From: Sue Howell
Sent: 05 December 2018 14:44
To: Planning.Responses
Cc: Michael Eastham
Subject: FW: planning application Ref: WA/95/18/RES

Comment from Greenspace

APPLICATION WA/95/18/RES

Site Address: Land east of Tye Lane Walberton

Tree Survey & Constraints with Shading

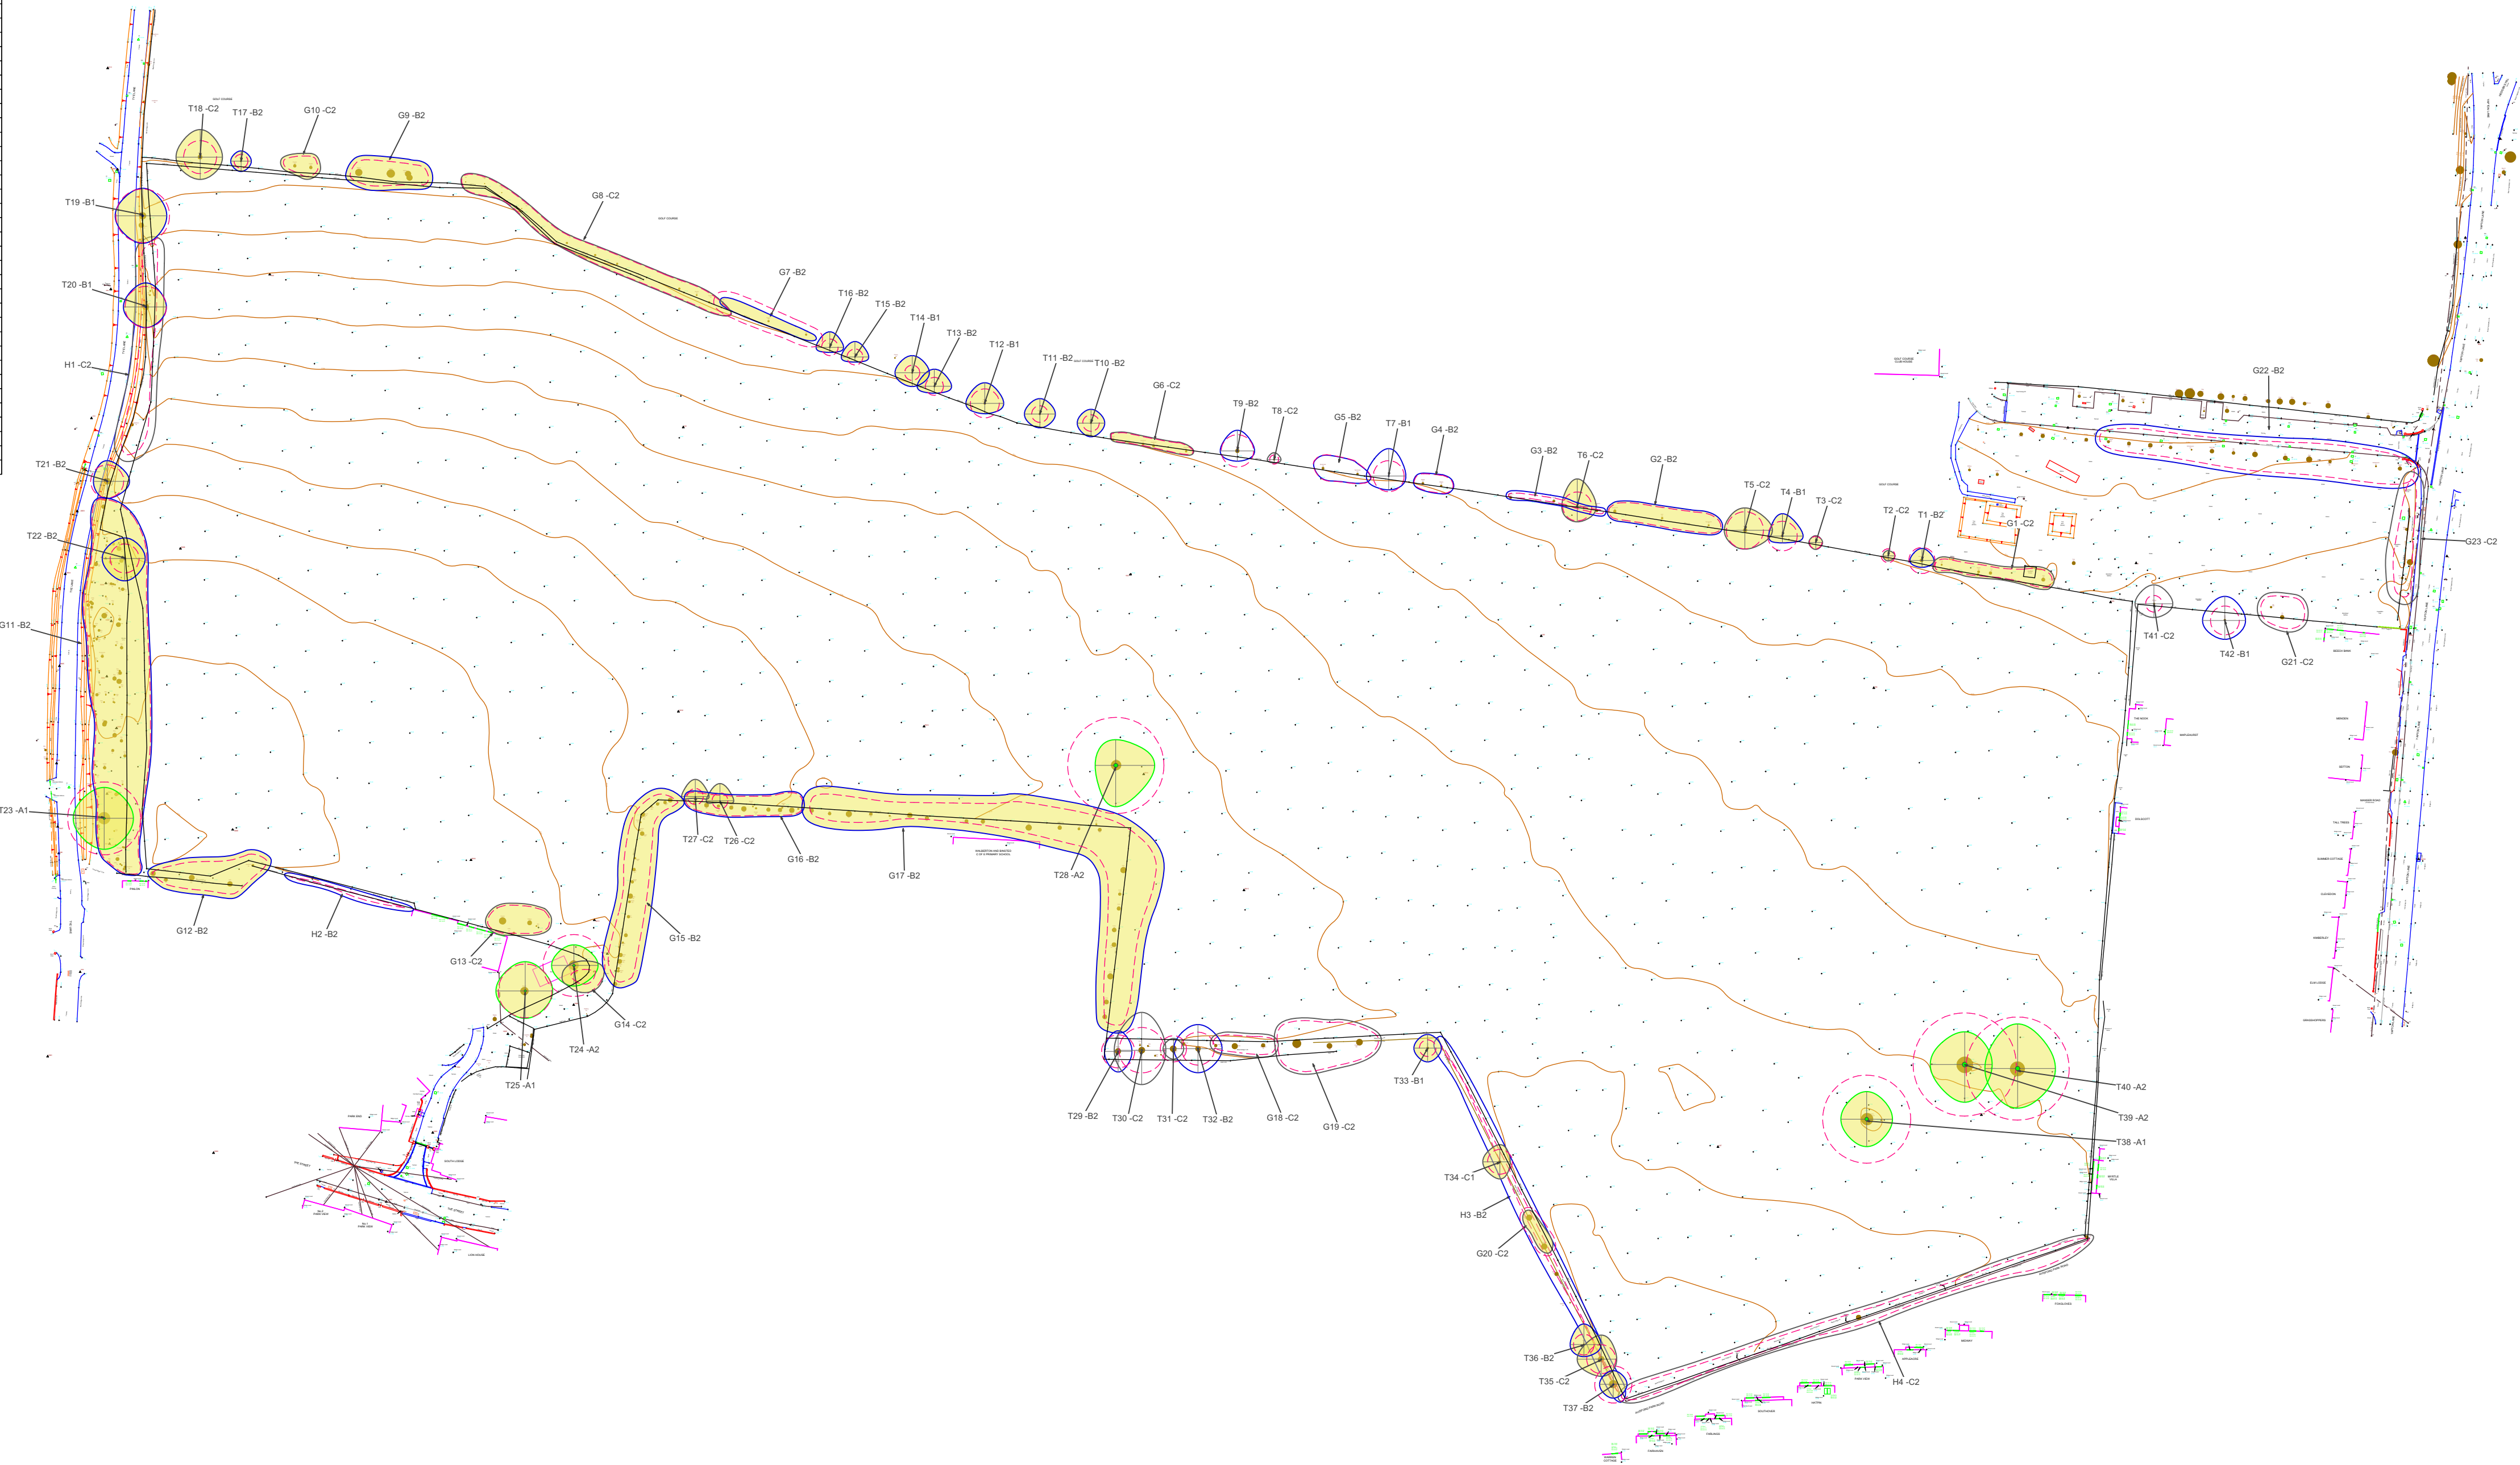
The application site sits within an open rural fringe which has far reaching views. Consideration must be given to the retention of existing vegetation to the periphery and to be mindful of any construction or site trafficking which may affect existing and neighbouring vegetation which would need to be protected in line with BS 5837:12 Any tree works to the site to be in agreement with Arun District Councils Tree Officer.

The site is screened to some minor degree to the boundaries with significant and valuable tree cover and areas where screening may be required to the properties which lie to the south and east of this proposal. A substantial planting scheme with a selection of semi mature specimens will be required to provide screening to these neighbours. New planting proposals must also be considered in relation to the wider viewpoints. Consideration should be given to species choice for these locations. New planting proposals would be required to be plotted in plan form showing the location of these with quantities proposed, densities and size at time of planting.

Any trees or vegetation that fall within the proposed or periphery of the development, may provide significant aesthetic impact to the location. Any trees in particular along the boundaries, which adjoin neighbouring land could provide potential valuable screening and should be retained particularly those adjoining the settlement boundary. Any considered tree removal from this site should be agreed with Arun District Councils Tree Officer. Root protection Areas (RPA) should extend into the development site and to those in neighbouring land. Before construction, a tree protection scheme must be in place for any retained trees including trees whose root protection areas fall within the construction zone from neighbouring land. This should be in accordance with BS 5837:2012 'Trees in relation to construction' Any removed trees should be mitigated for allowing for inclusion of native species for biodiversity purposes and fitting to the semi-rural setting.

Vegetation to the boundaries to be retained
